Principal Areas of Disagreement Summary Statement (PADSS) from Surrey County Council - Version Number: One Submitted at: Pre-examination - 29<sup>th</sup> October 2023

Figure 1. Reptile Trapping Area A and Receptor Site

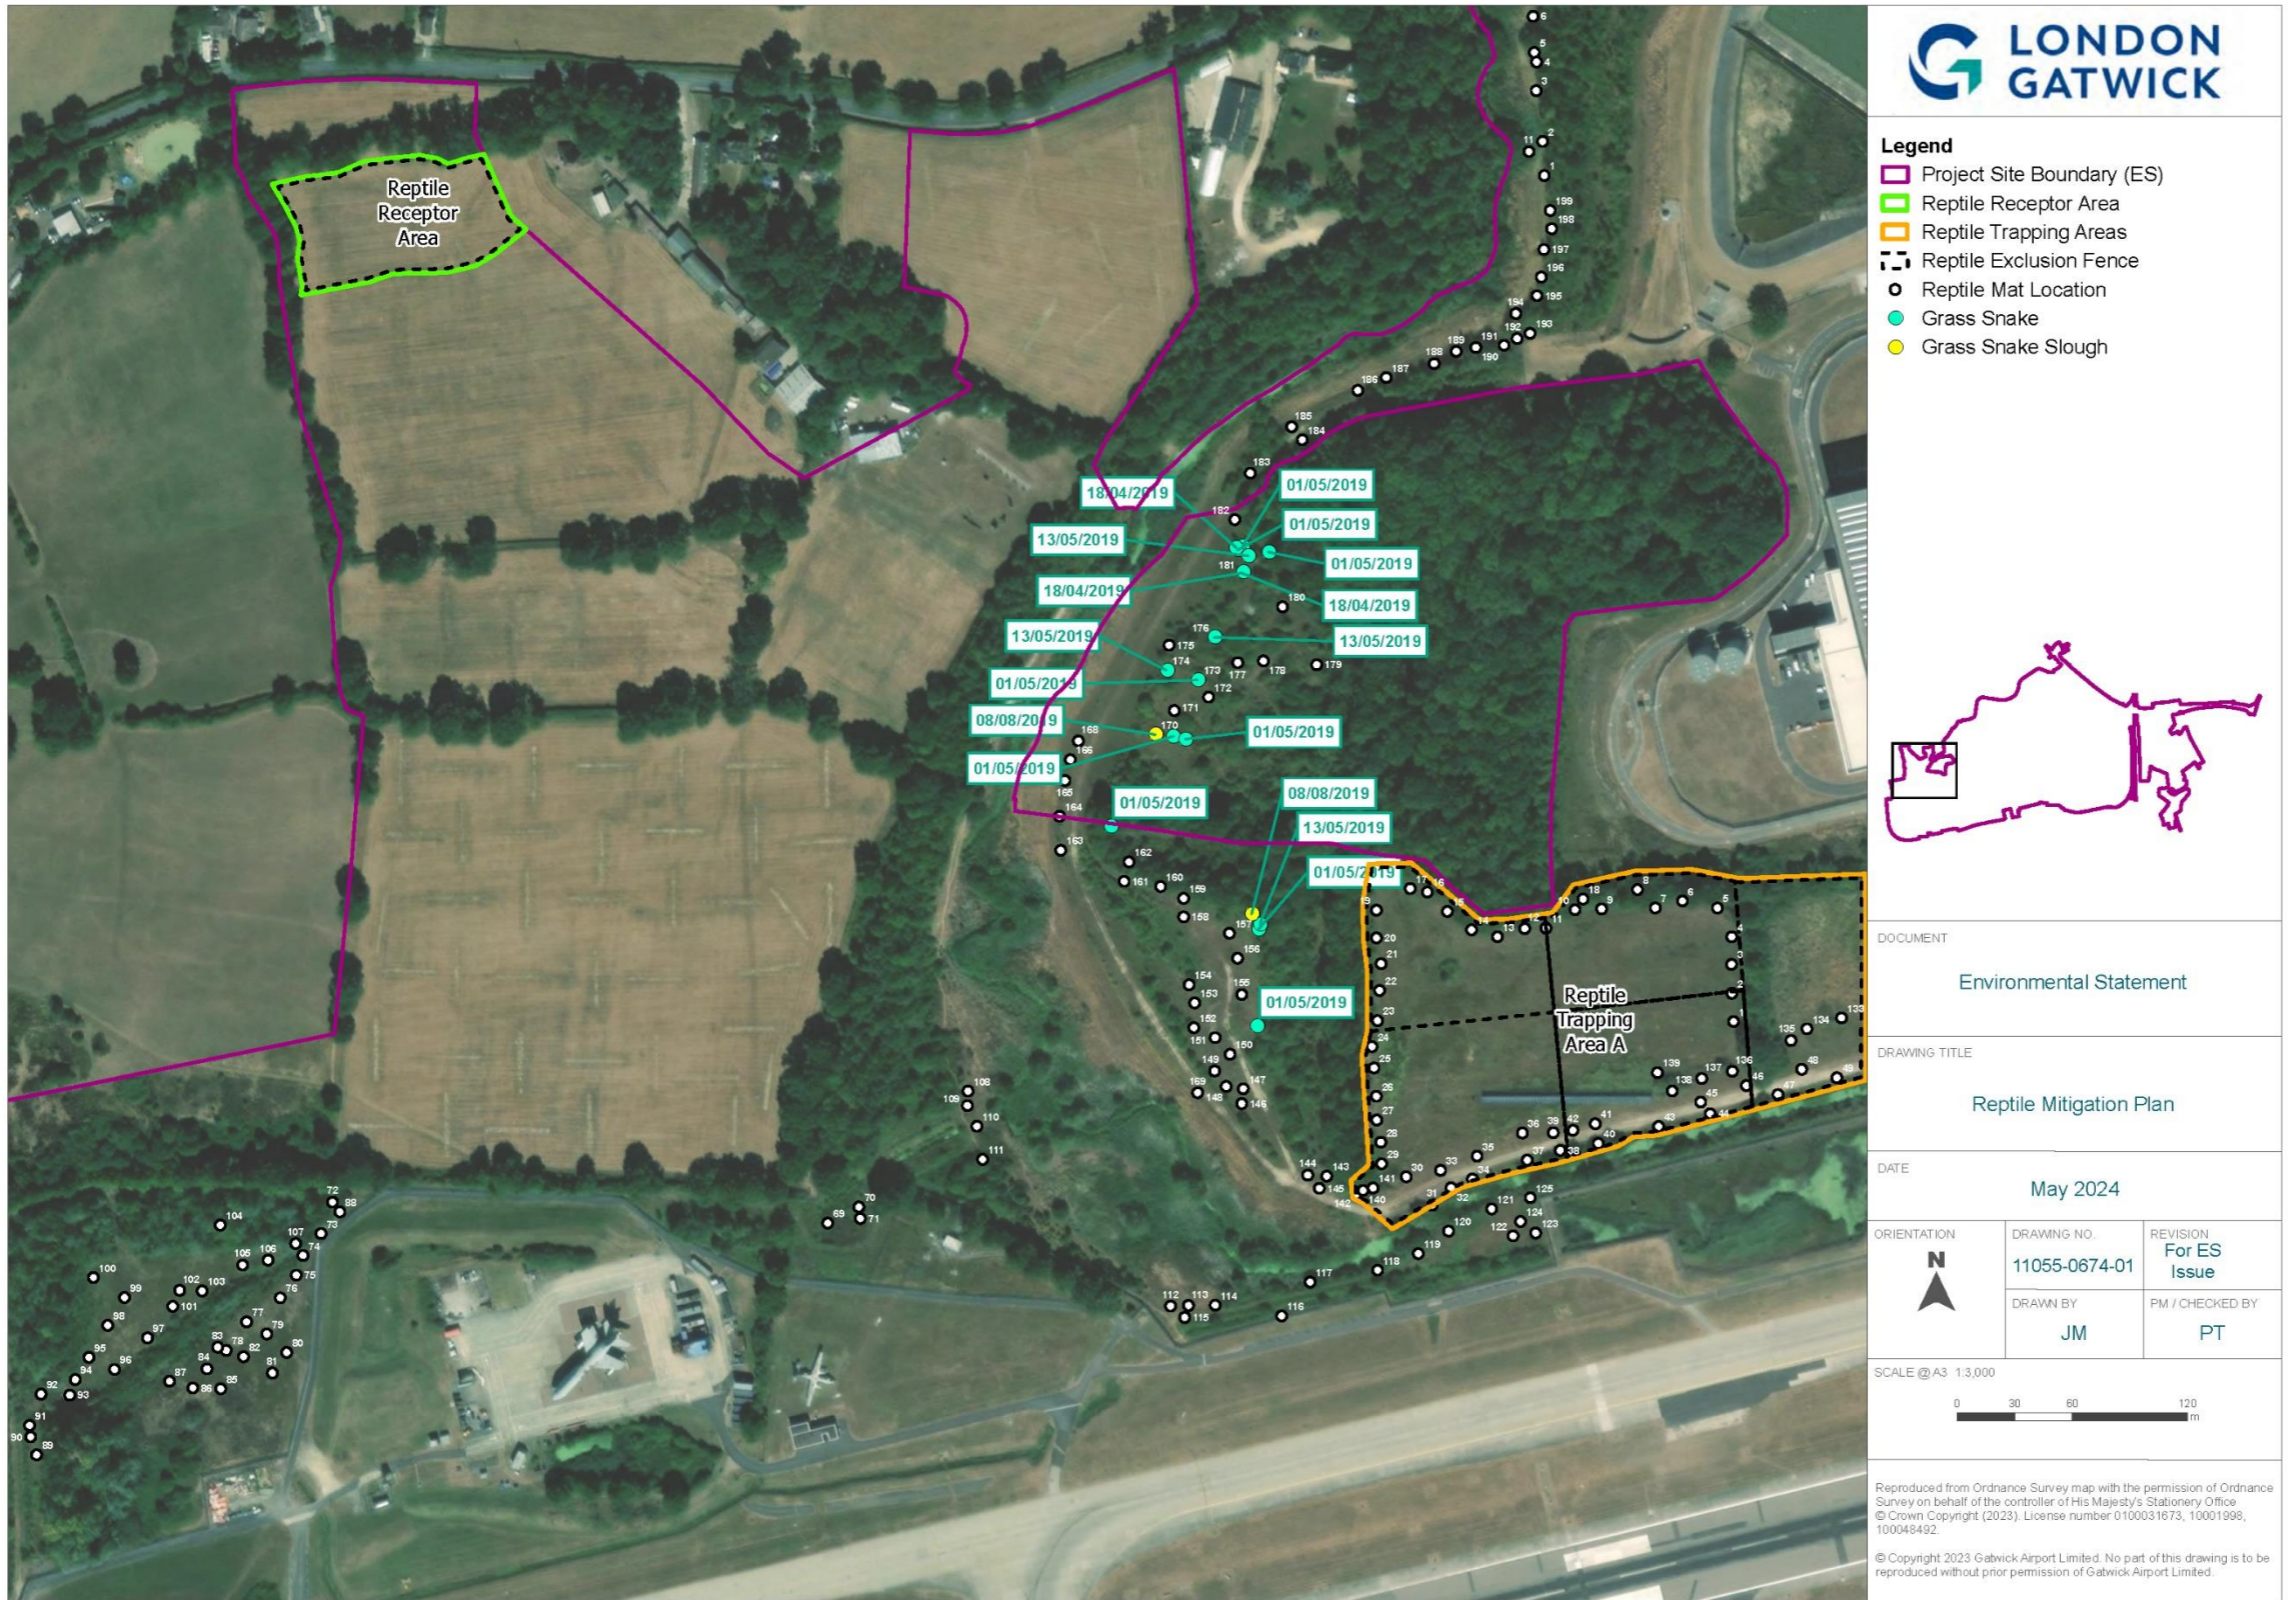
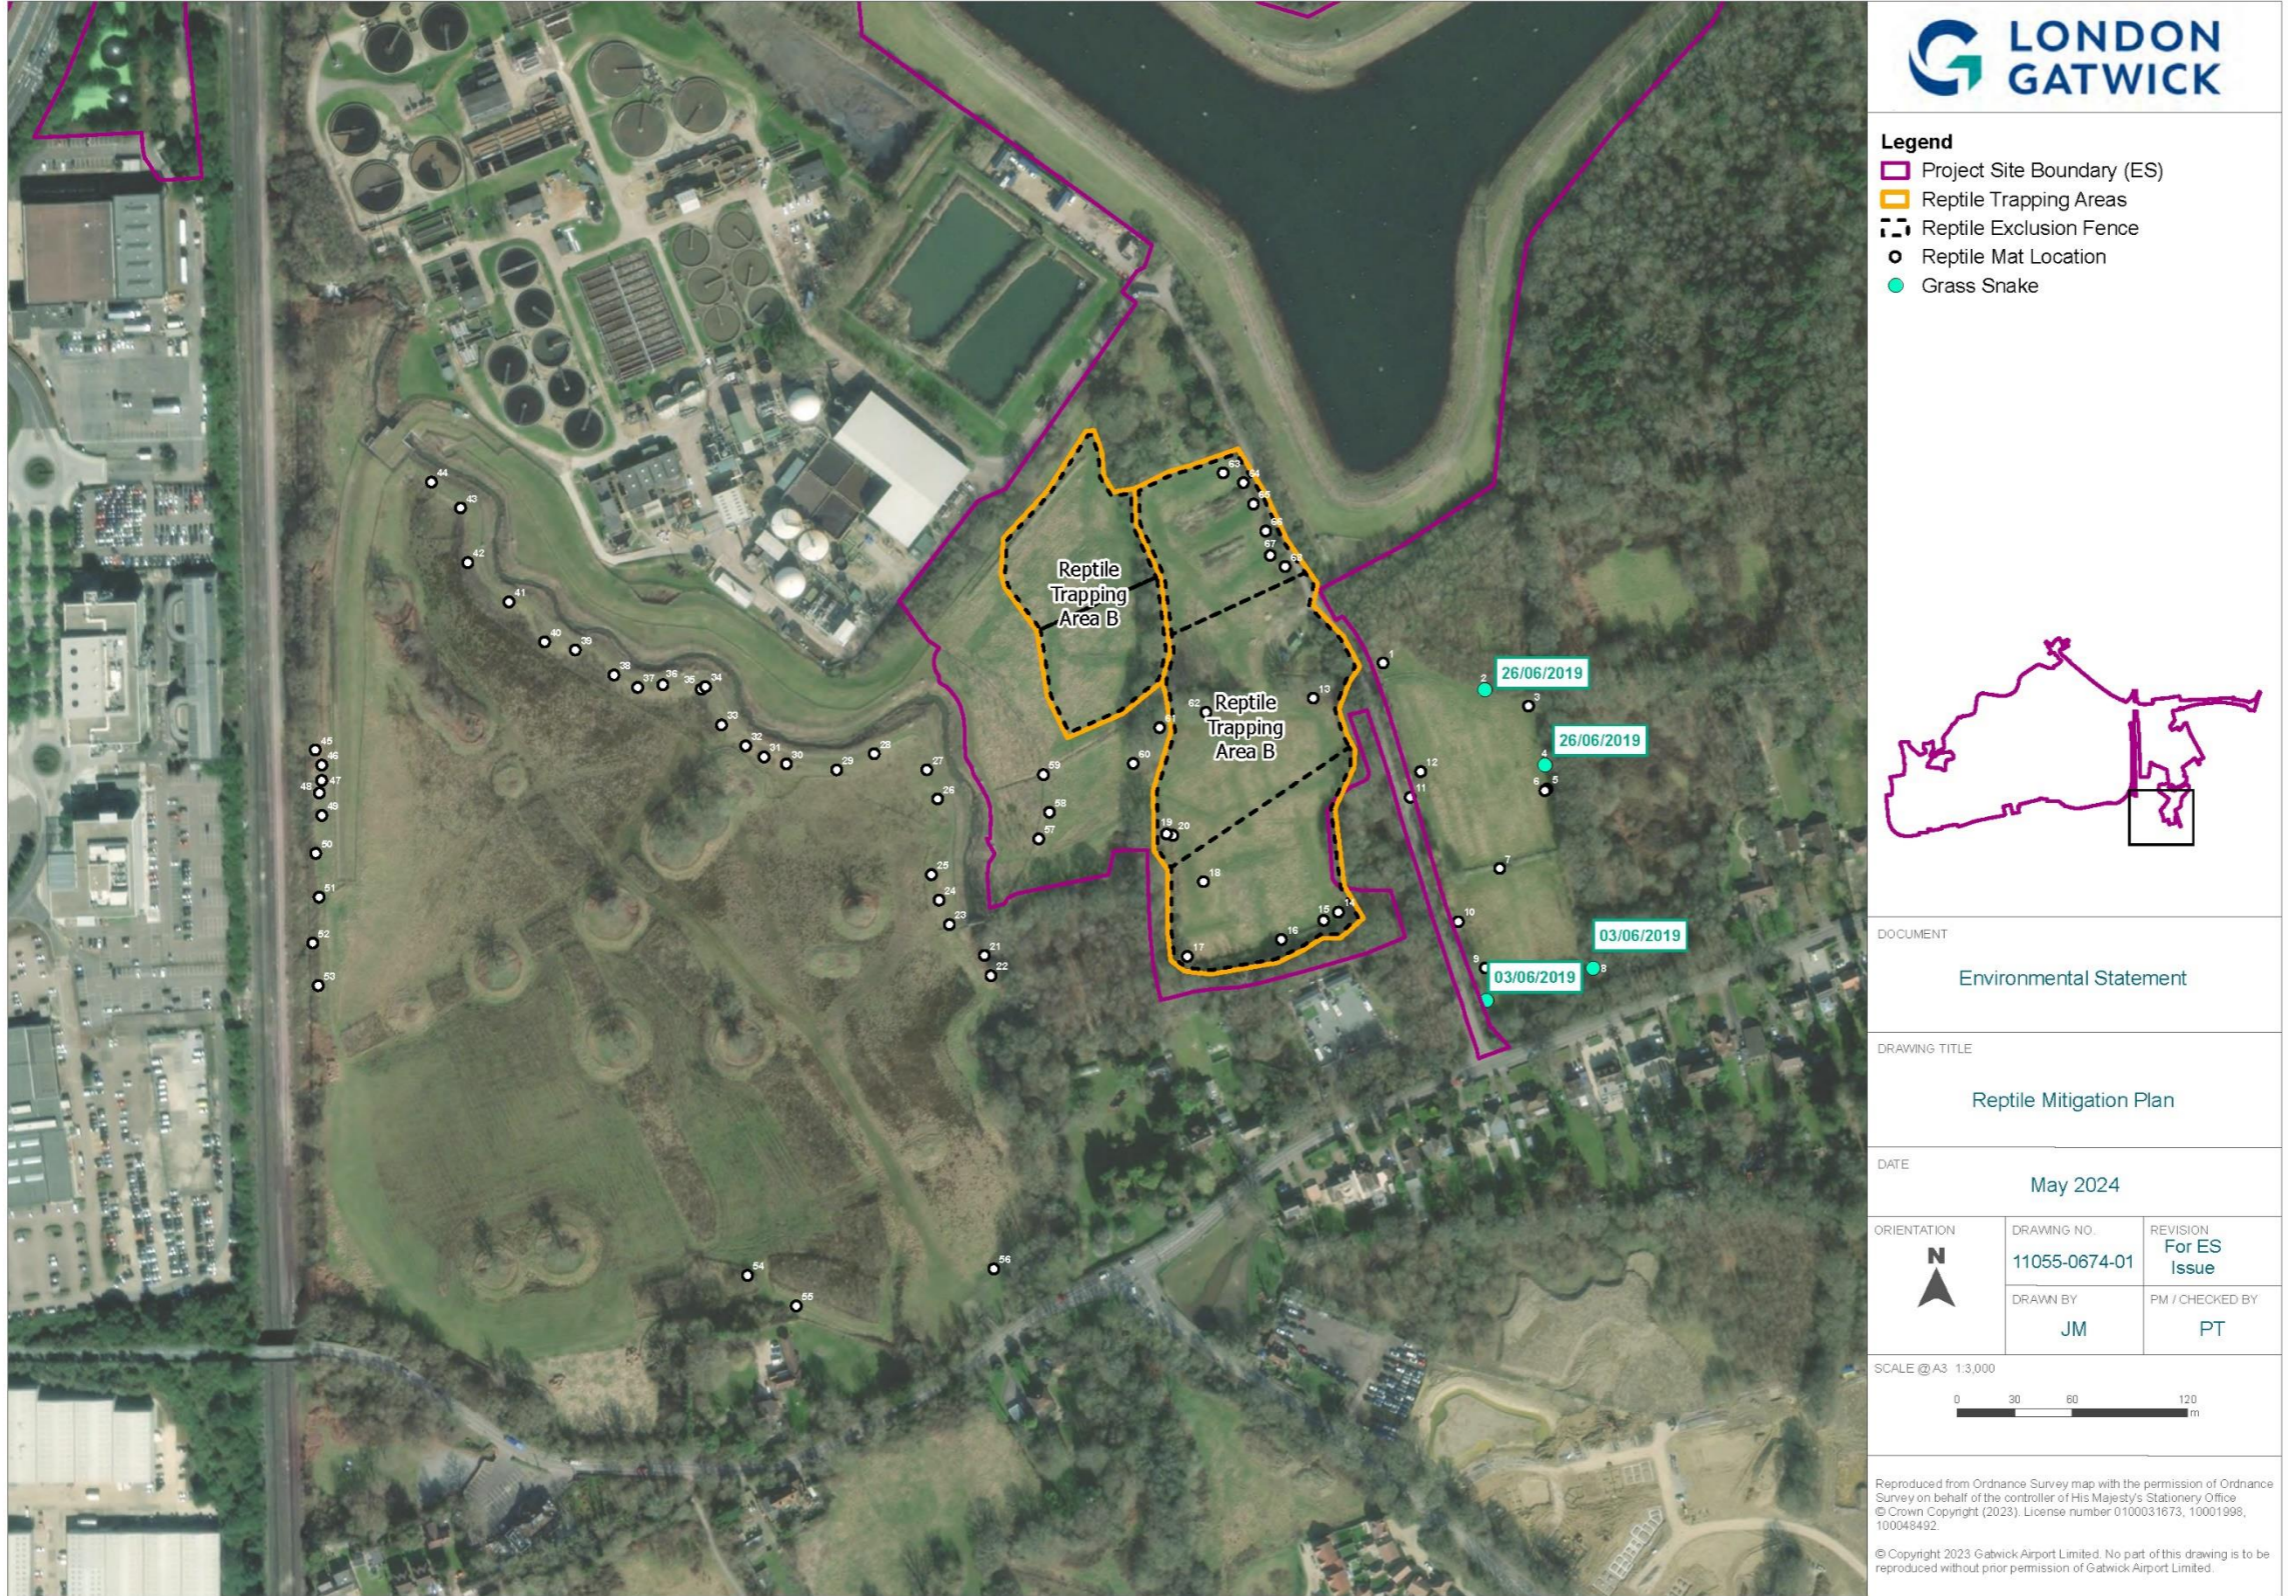
69	Lack of information on reptile and great crested newt (GCN) mitigation	<p>The ecology chapter for the ES states that reptile and GCN mitigation will involve translocation to receptor sites and where relevant, European Protected Species Licences would be applied for post DCO consent. However, no detailed information is provided for the reptile and GCN mitigation strategy, for example:</p> <ul style="list-style-type: none"> <li>• Where are the receptor sites? Reference is made to Longbridge Roundabout, Museum fields and other mitigation areas but there is no detail as to which one of these has been chosen to be the receptor locations for reptiles and GCN.</li> <li>• No methodology or timings information for the mitigation strategies.</li> </ul>	More detail required on proposed receptor sites and outline mitigation strategies for reptiles and GCN should be provided.	Likely
70	No compensation provided for loss of ponds	The ecology chapter states that no replacement ponds will be provided within the application site due to airport	Replacement ponds should be provided off-site – preferable	Uncertain
